Application for a non-material amendment following a grant of planning permission.
Town and Country Planning Act 1990

Non-material amendment following the grant of AW/344/15/NMA to increase rear bi-fold door width, increase length of proposed ground floor east elevation wall, replace cedar cladding to proposed east elevation with decorative render + 2 No. additional rooflights to west elevation.

House:	27	Suffix:	
House name:			
Street address:	Aldwick Gardens		
Town/City:	ALDWICK		
Postcode:	PO21 3QT

Proposed Extension.
Proposed Ground Floor Plan.
 Scale: 1:50. Drg No.: 7349/01p
 Date: April 2017
 All dimensions to be checked on site.
 Do not scale except for planning purposes.

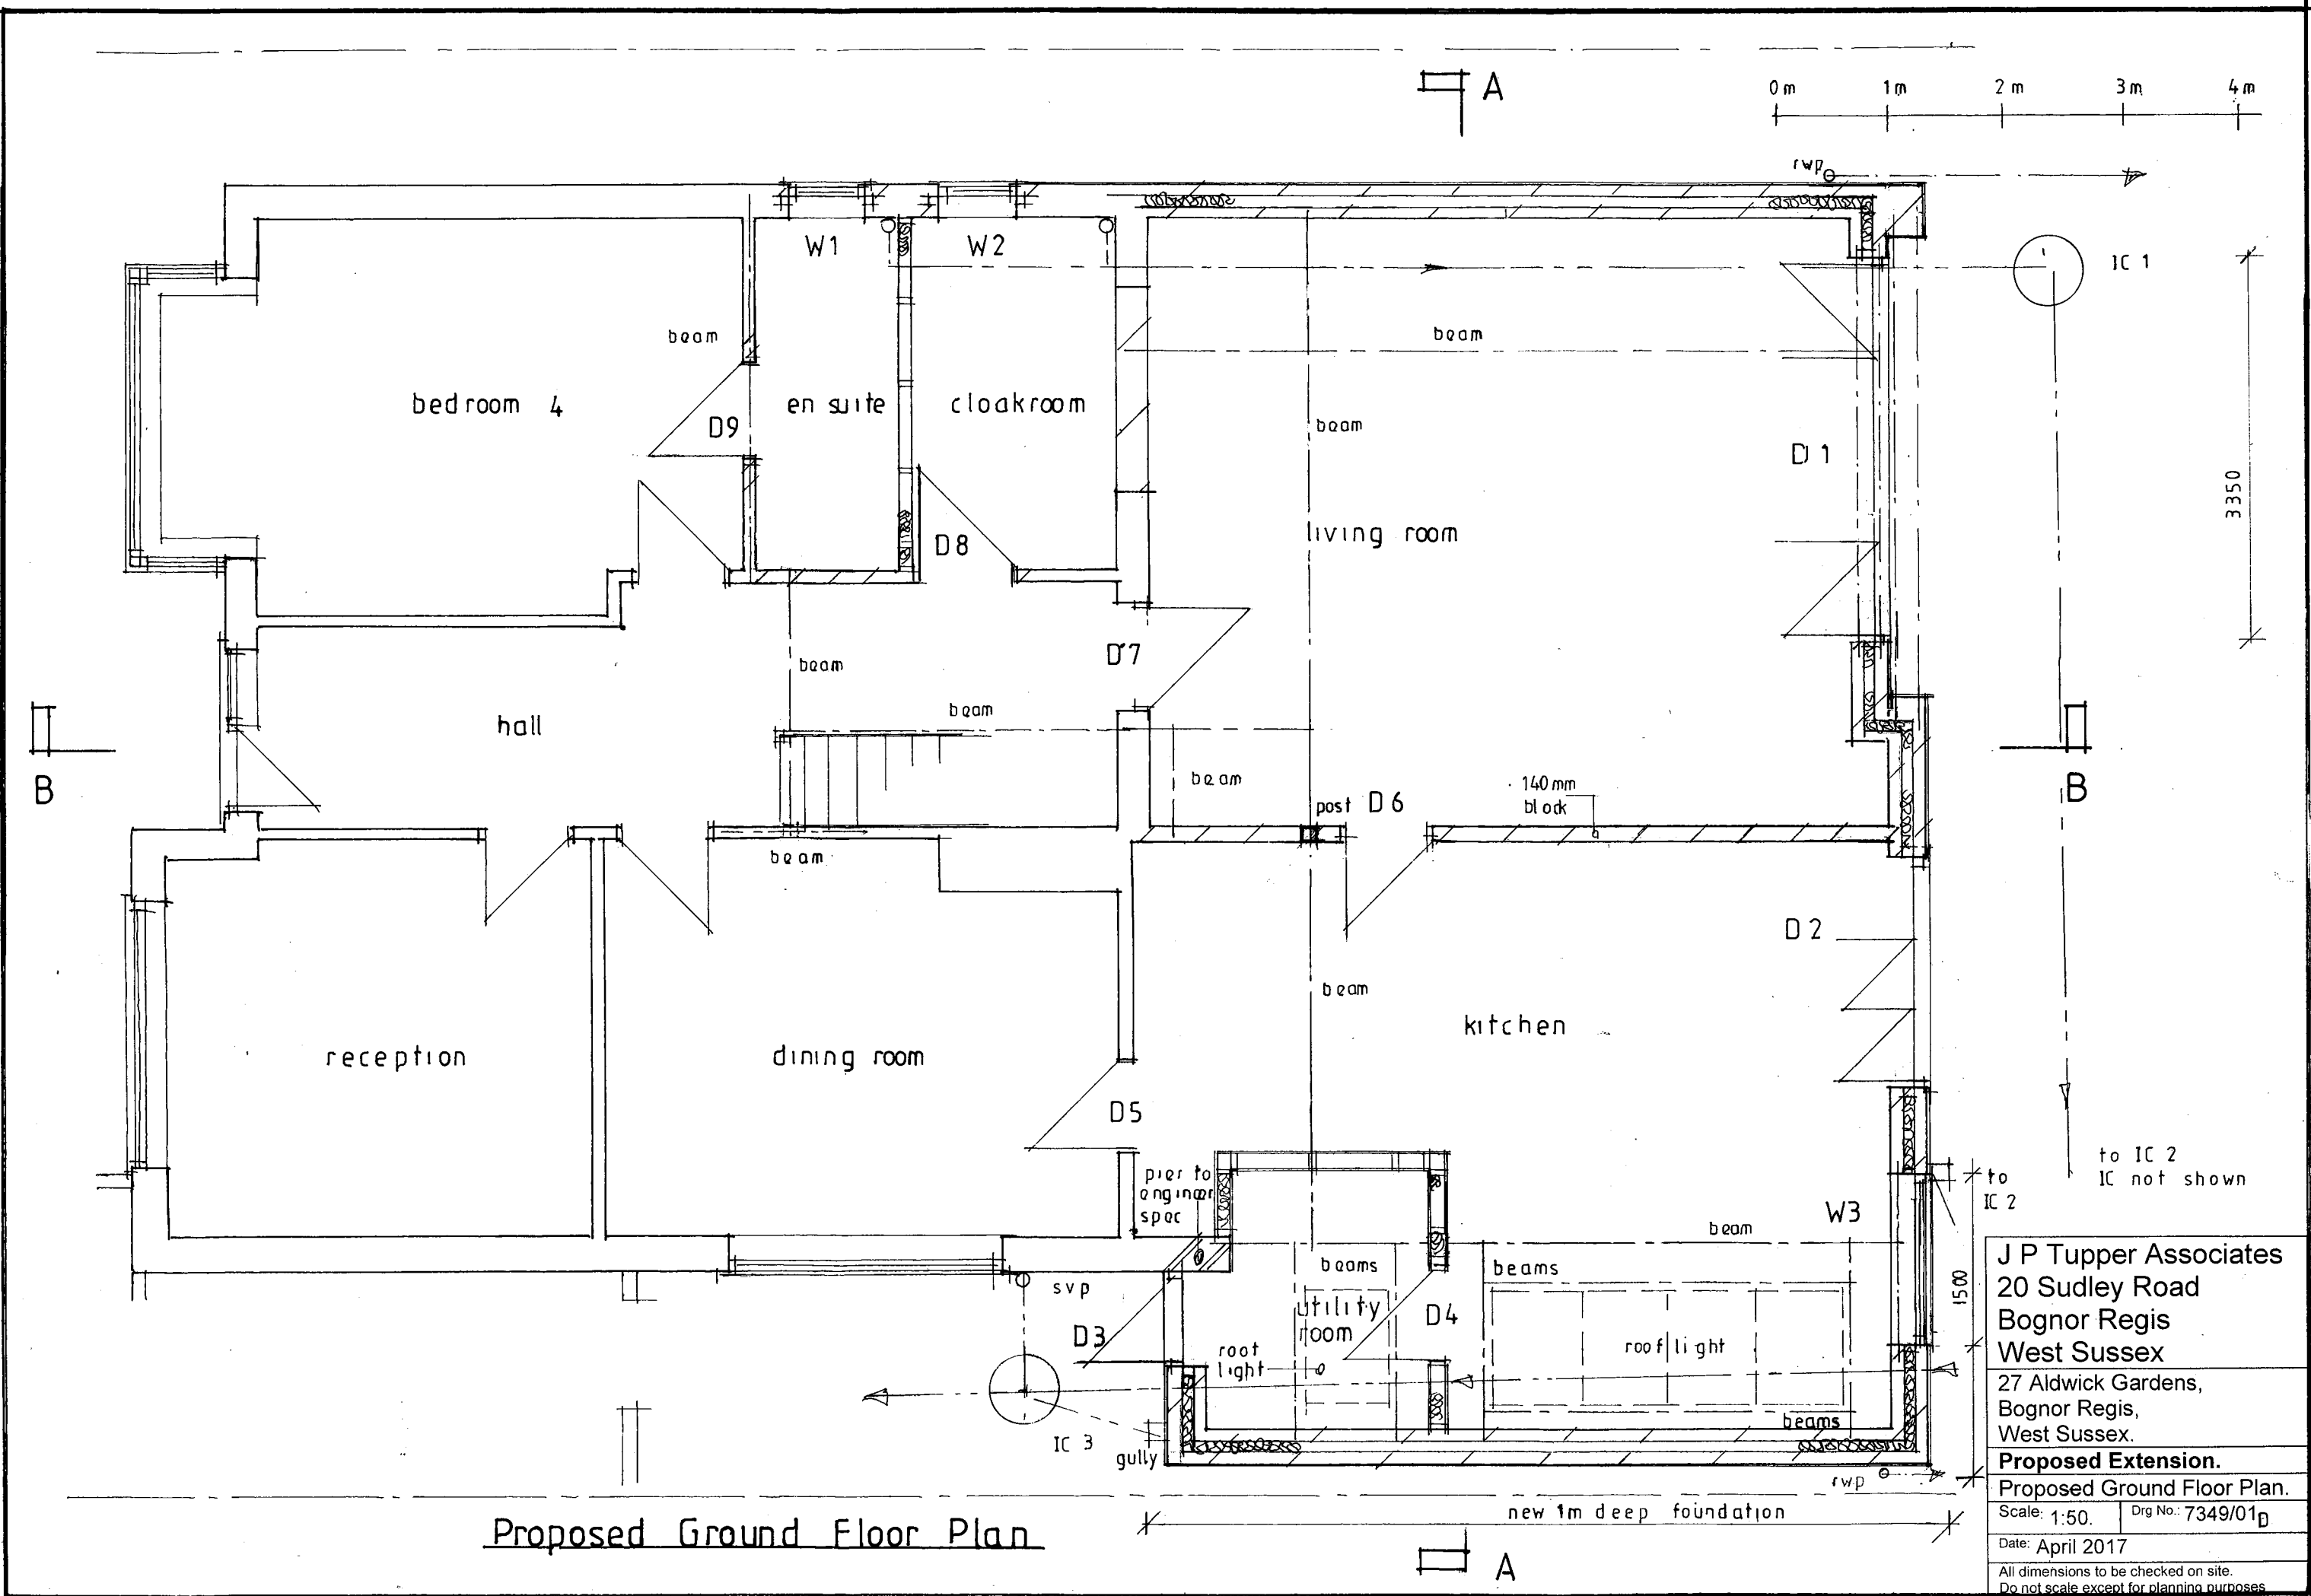
Increasing the rear bi-fold door width to 3.35m.

Increasing the length of the proposed ground floor east elevation wall by 300mm and replacing the cedar cladding to the proposed east elevation with decorated render.

J P Tupper Associates 20 Sudley Road Bognor Regis West Sussex	
27 Aldwick Gardens, Bognor Regis, West Sussex.	
Proposed Extension.	
Proposed First Floor Plan.	
Scale: 1:50.	Dwg No.: 7349/02c
Date: April 2017	
All dimensions to be checked on site. Do not scale except for planning purposes

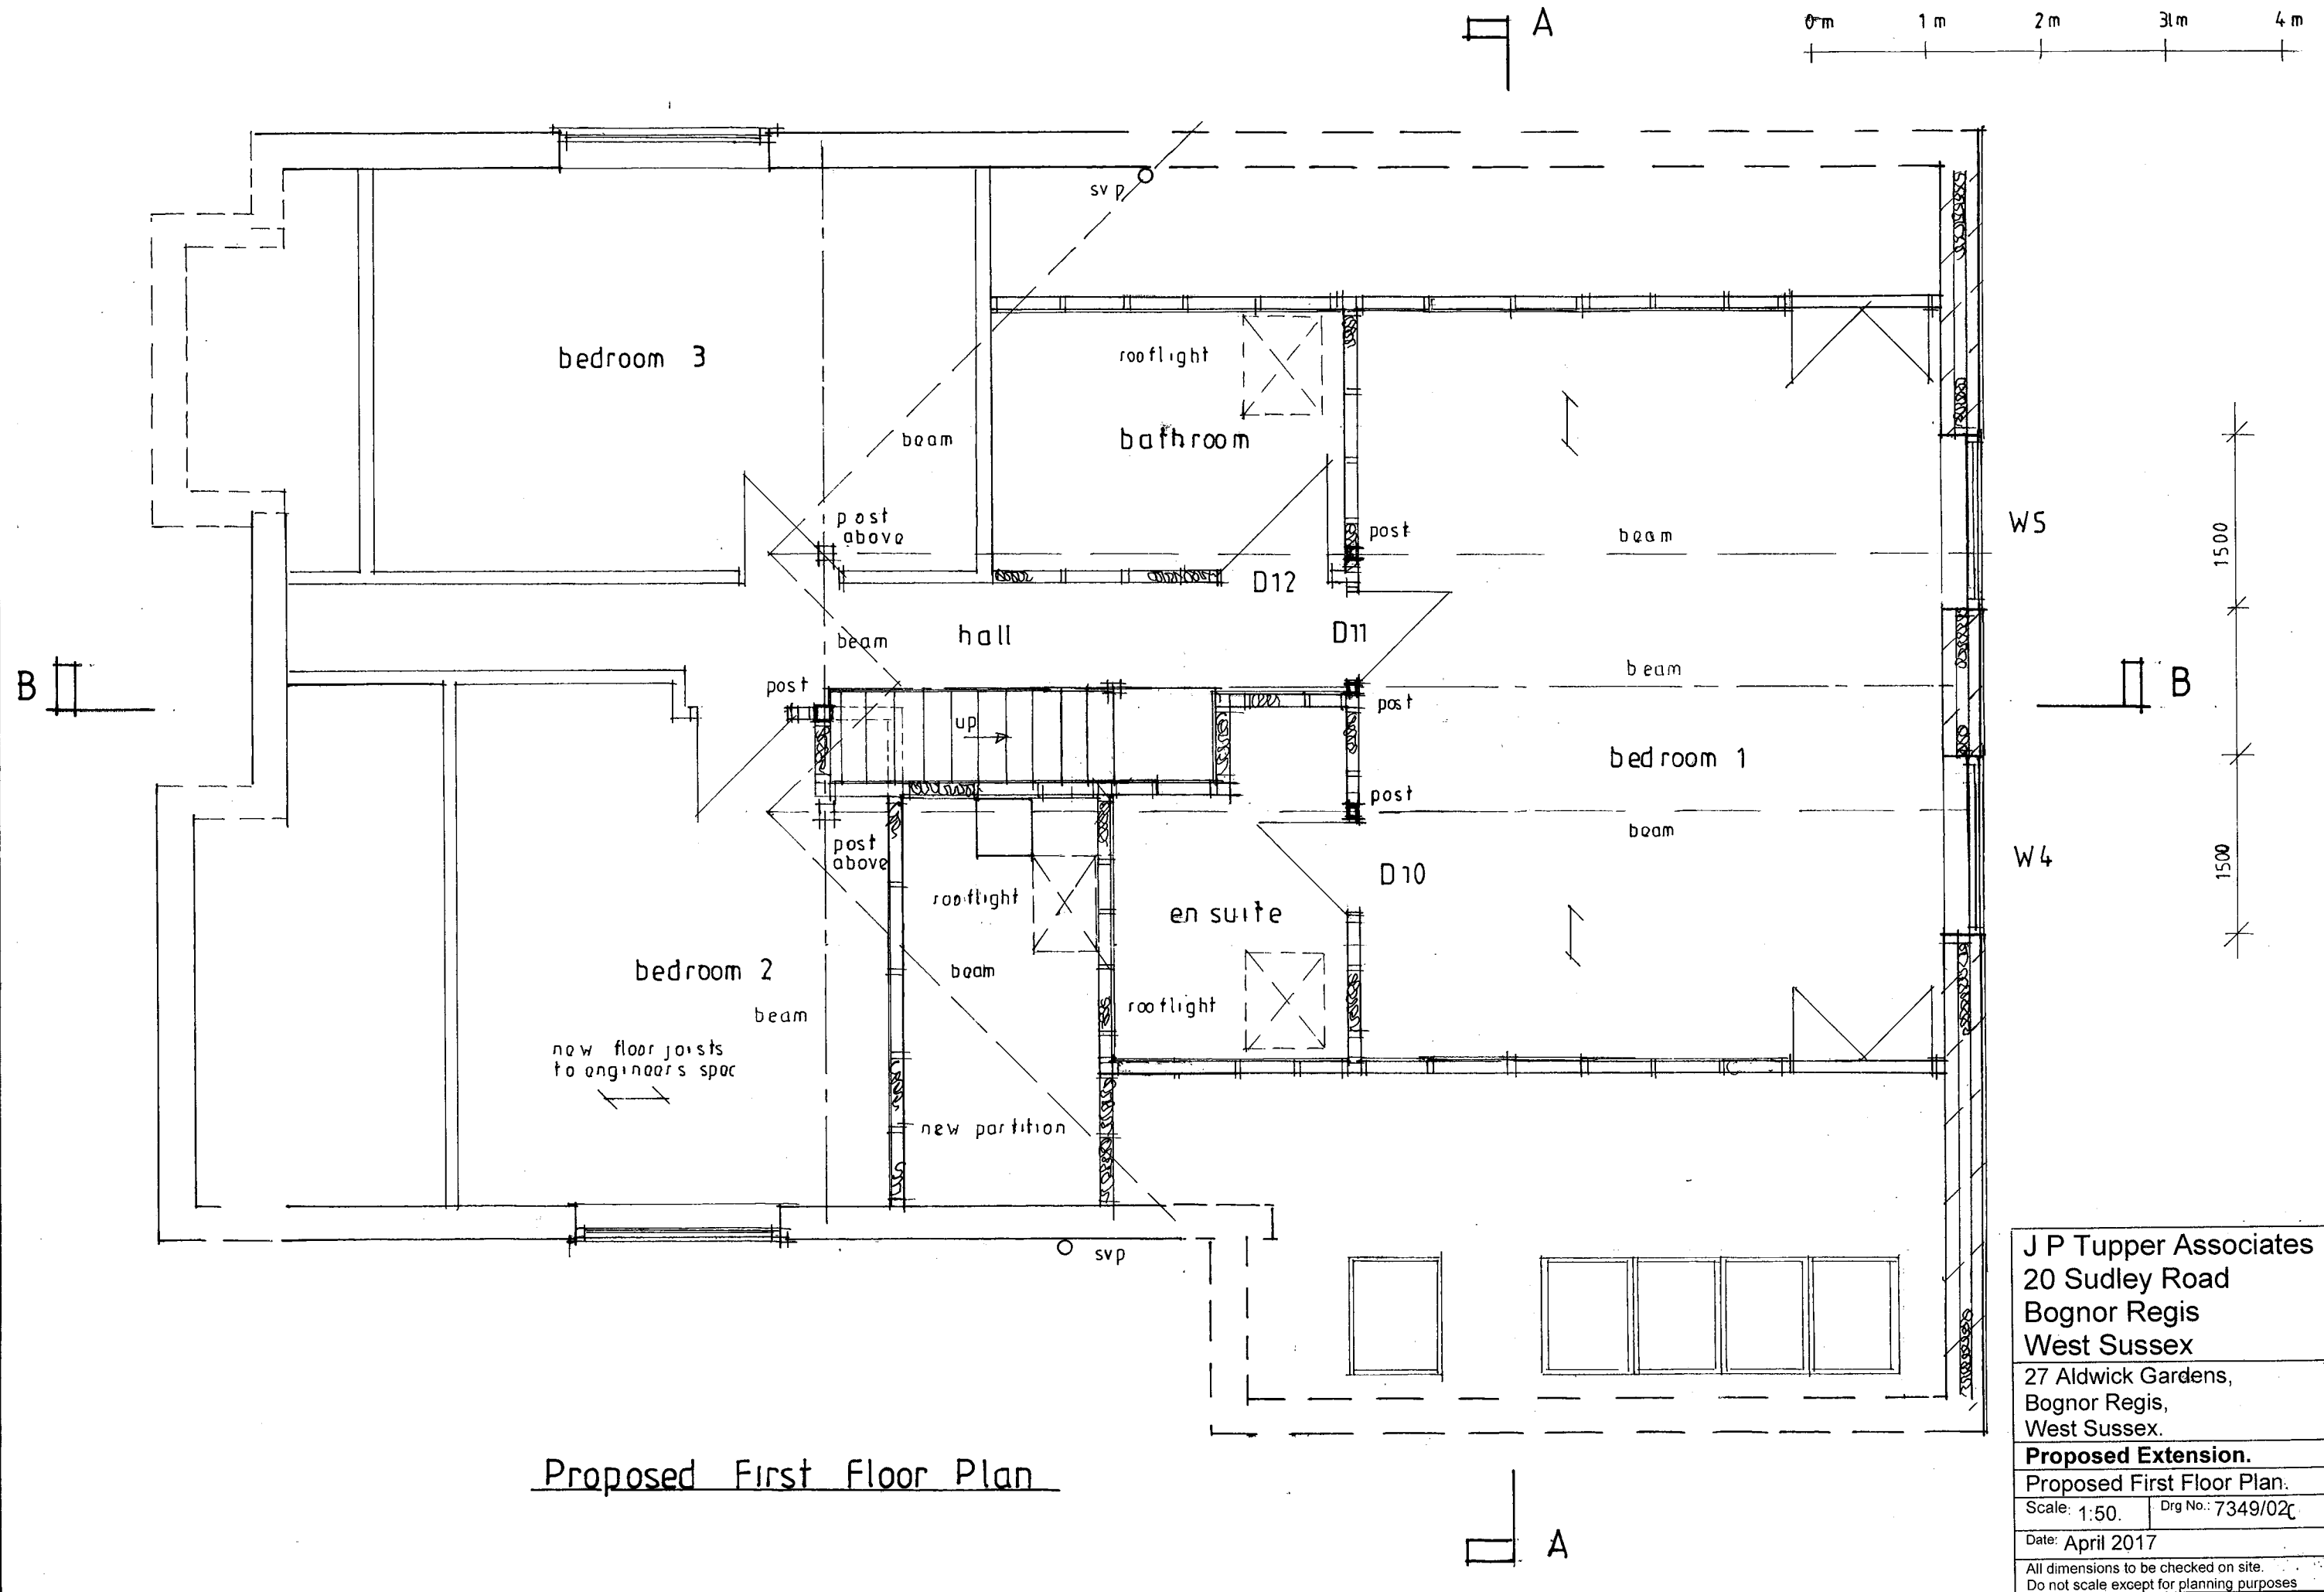
2 additional windows to the west elevation, 1 no. above the utility room and the 2nd at first floor level. The first floor window is to be in obscured glass and non opening within 1.7m of the first floor level.
